Five Estuaries Offshore Wind Farm Case  
Team  
Planning Inspectorate  
[FiveEstuaries@planninginspectorate.gov.uk](mailto:FiveEstuaries@planninginspectorate.gov.uk)  
**(By Email only)**

MMO Reference: DCO/2019/00008  
Planning Inspectorate Reference: EN010115  
Identification Number: 20049306

## **Planning Act 2008, Five Estuaries Offshore Wind Farm Ltd, Proposed Five Estuaries Offshore Wind Farm Order**

### **Additional Submission**

Figure 2-1: Mean herring larval lengths per sampling station (IHLS survey data (2012 – 2024) – Netherlands (December))

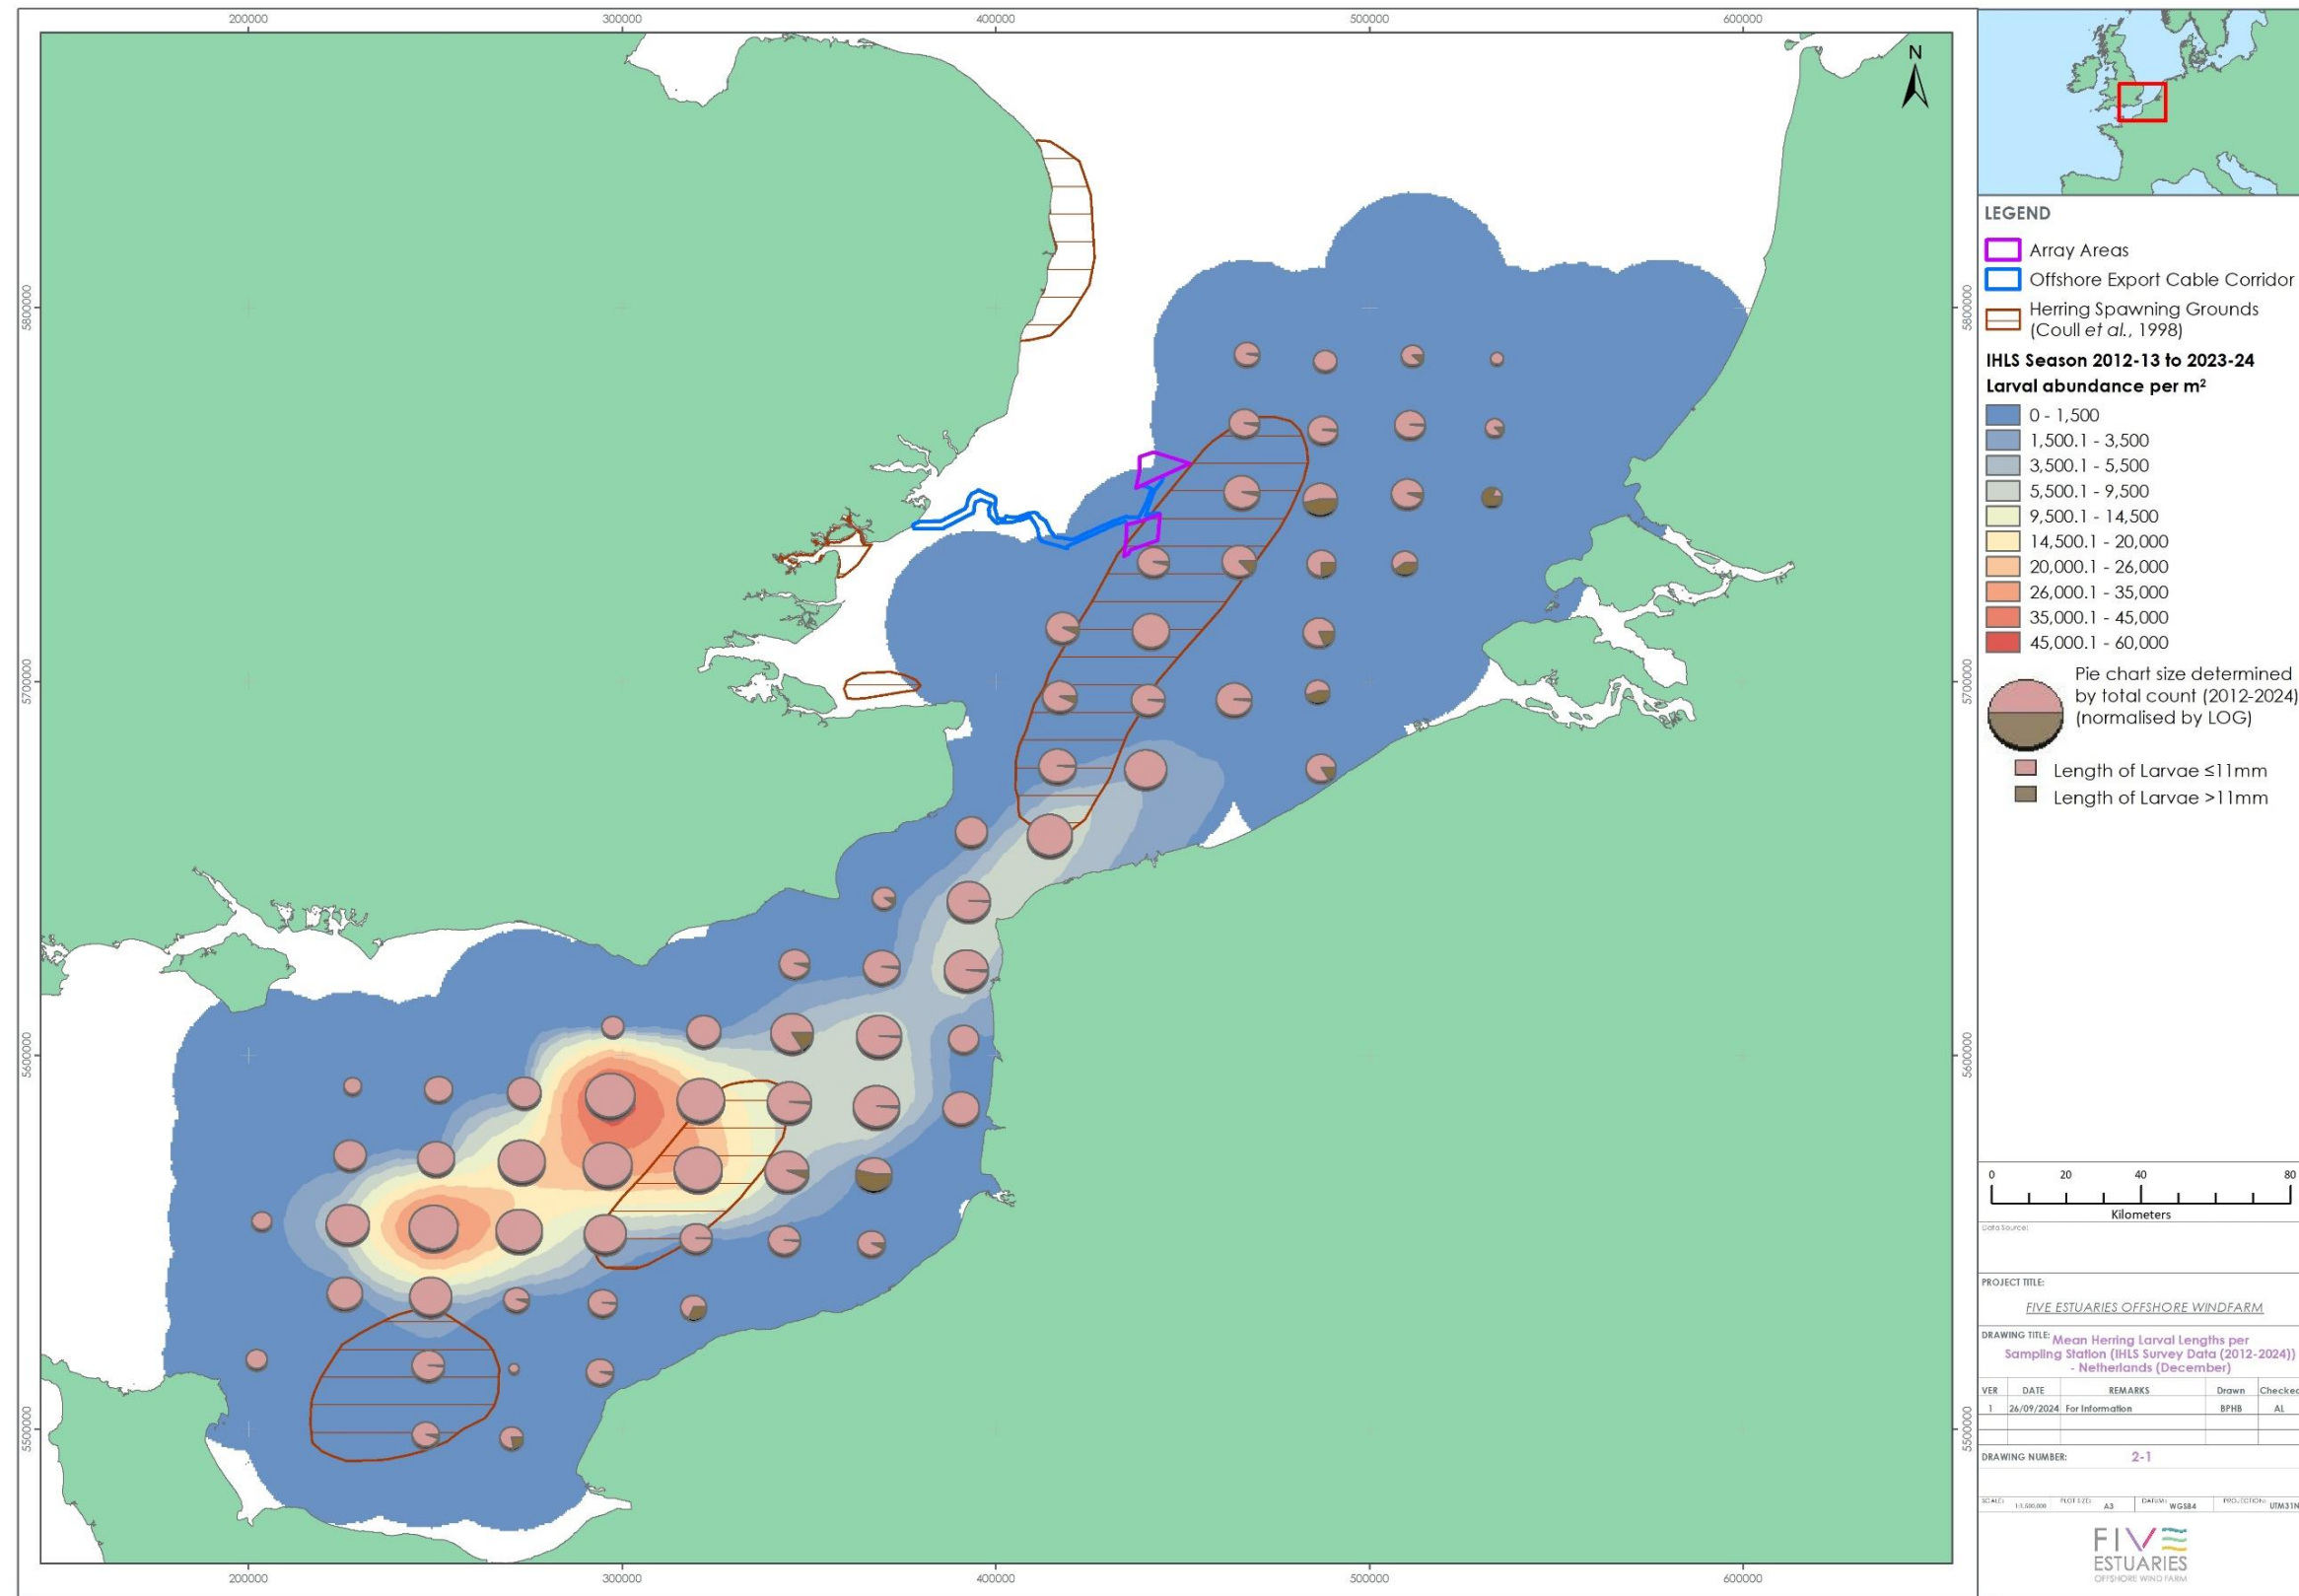
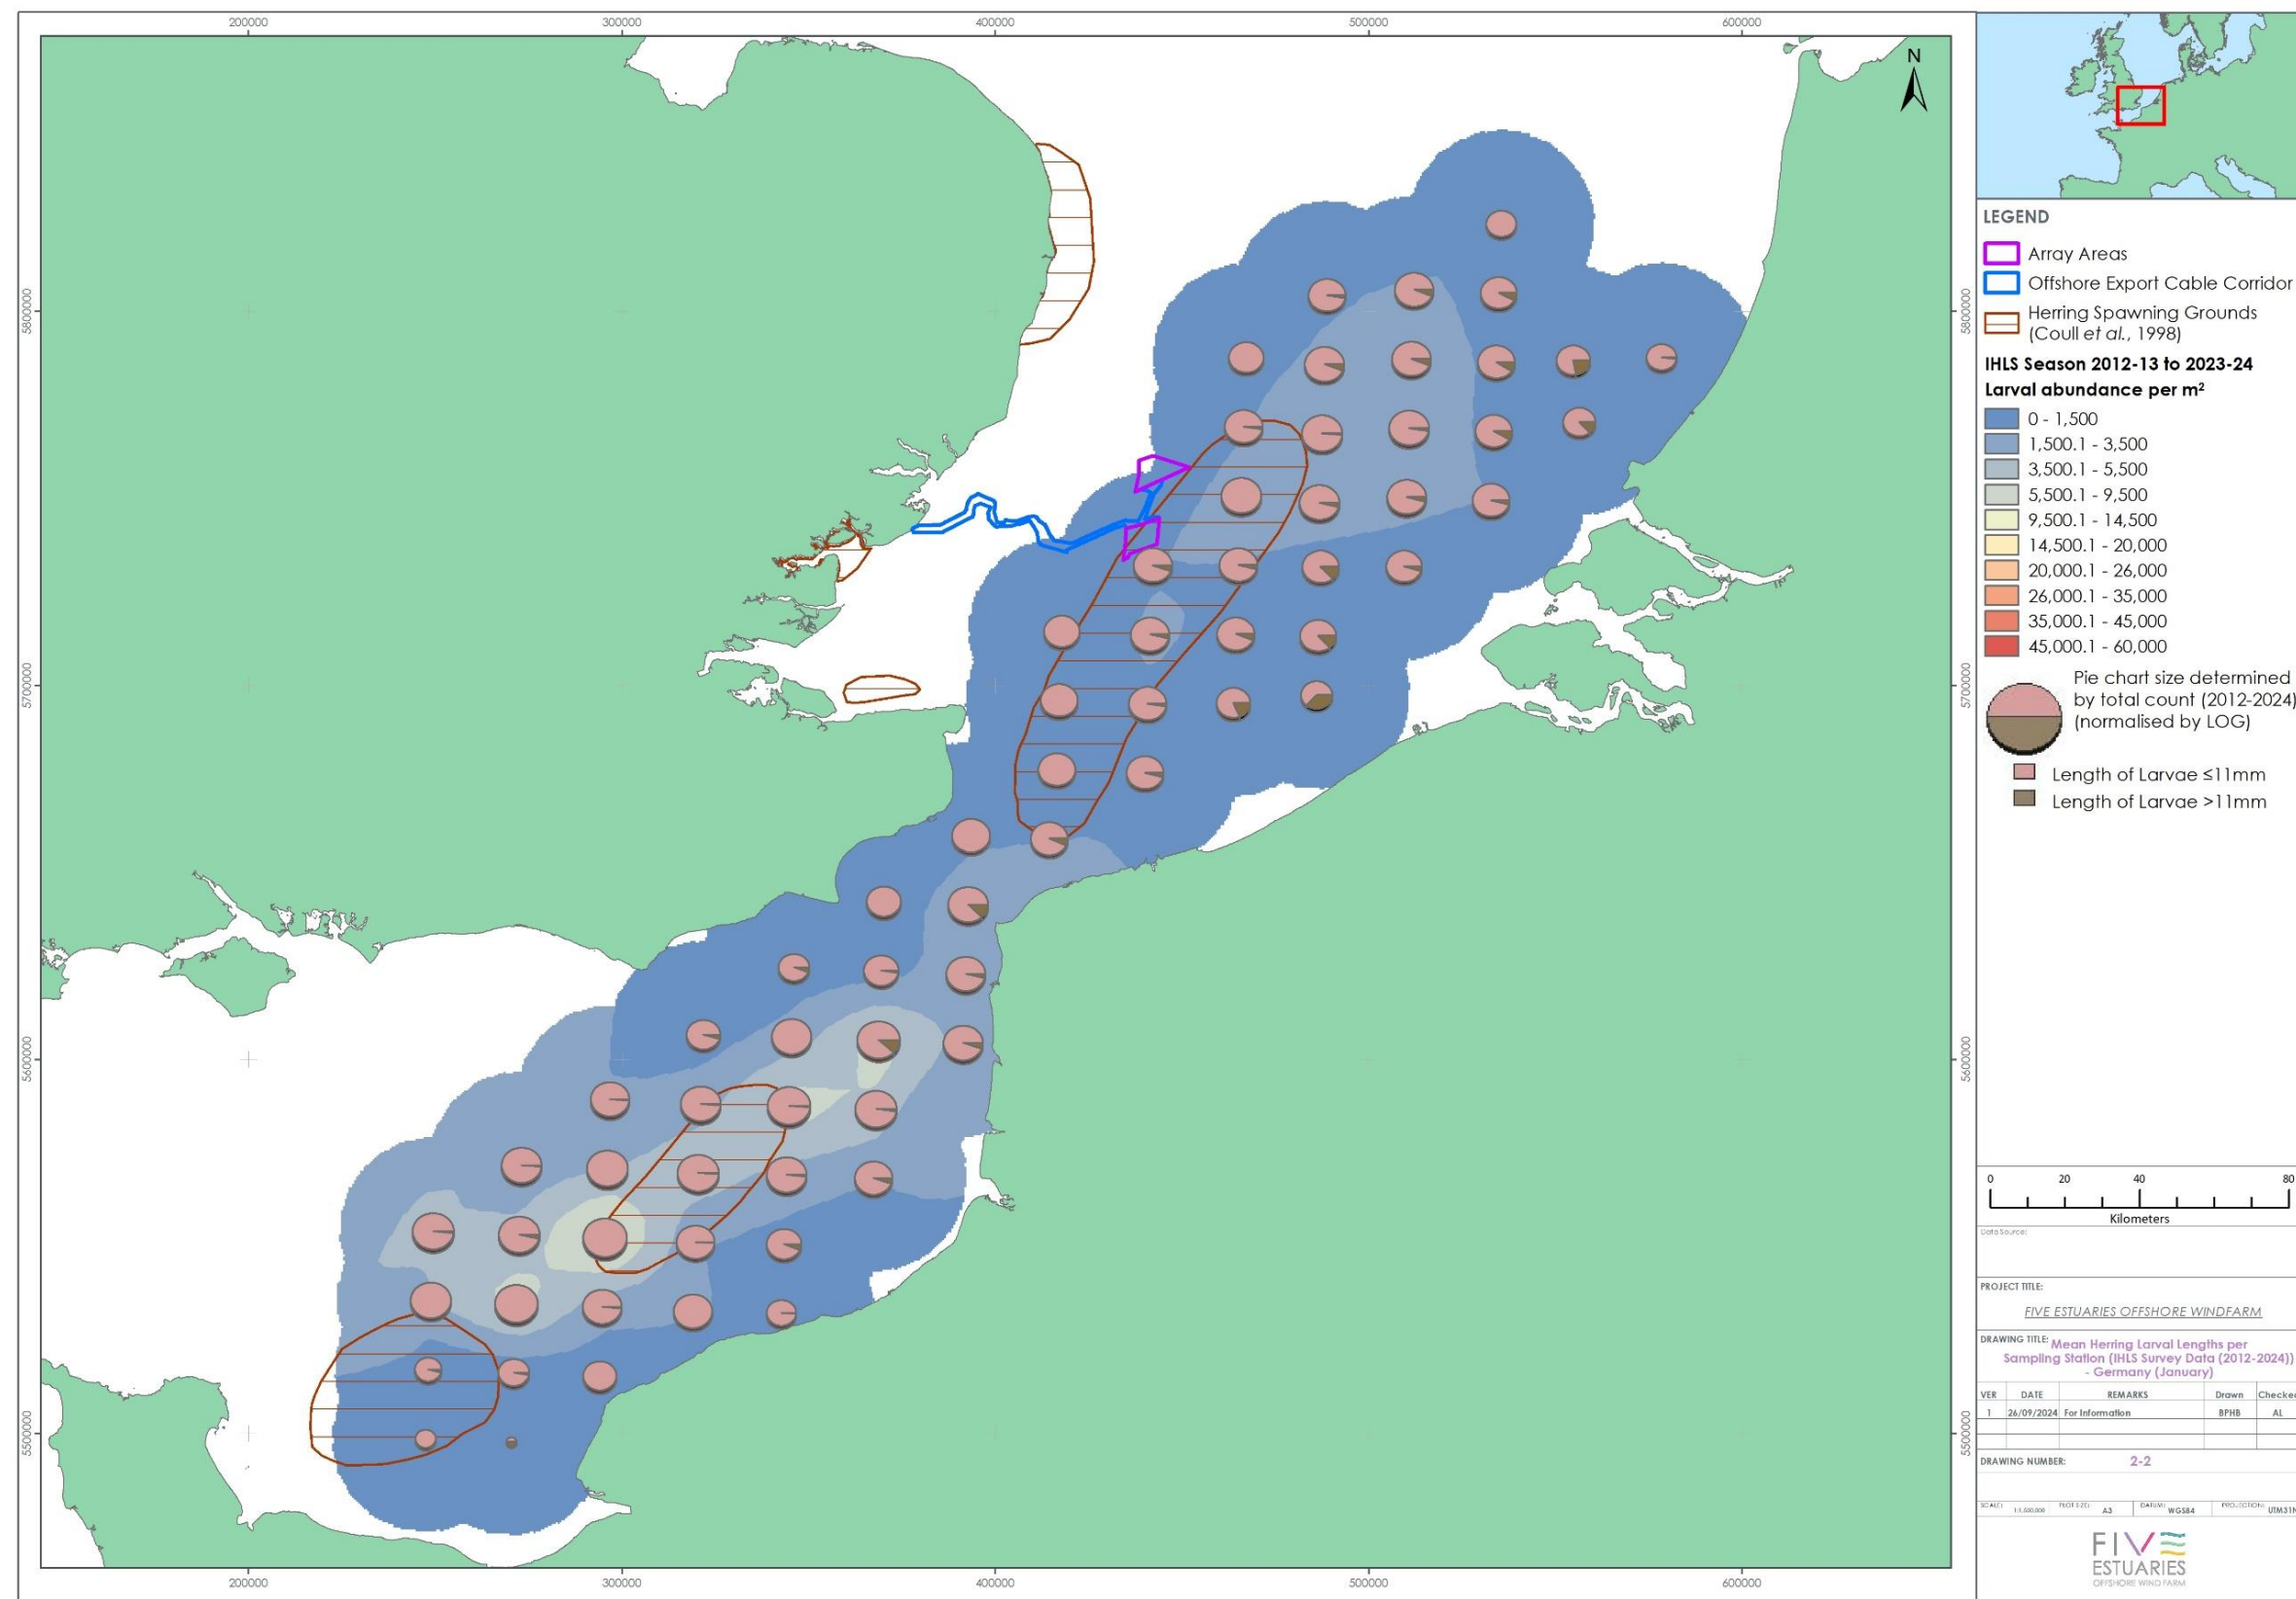
1.2.5. The MMO notes the Applicant has reviewed the IHLS larval length (catch length) data and plotted the mean herring larval lengths per sampling station from the IHLS data over a 10-year period (2012-2024) for each of the three survey periods (16-31 December, 1-15 January and 16-31 January) in Figures 2-1, 2-2 and Figure 2-3, respectively. Using this data, the Applicant has determined that a larval catch length of 11 millimetres (mm) is appropriate for use in the back-calculation. This length is
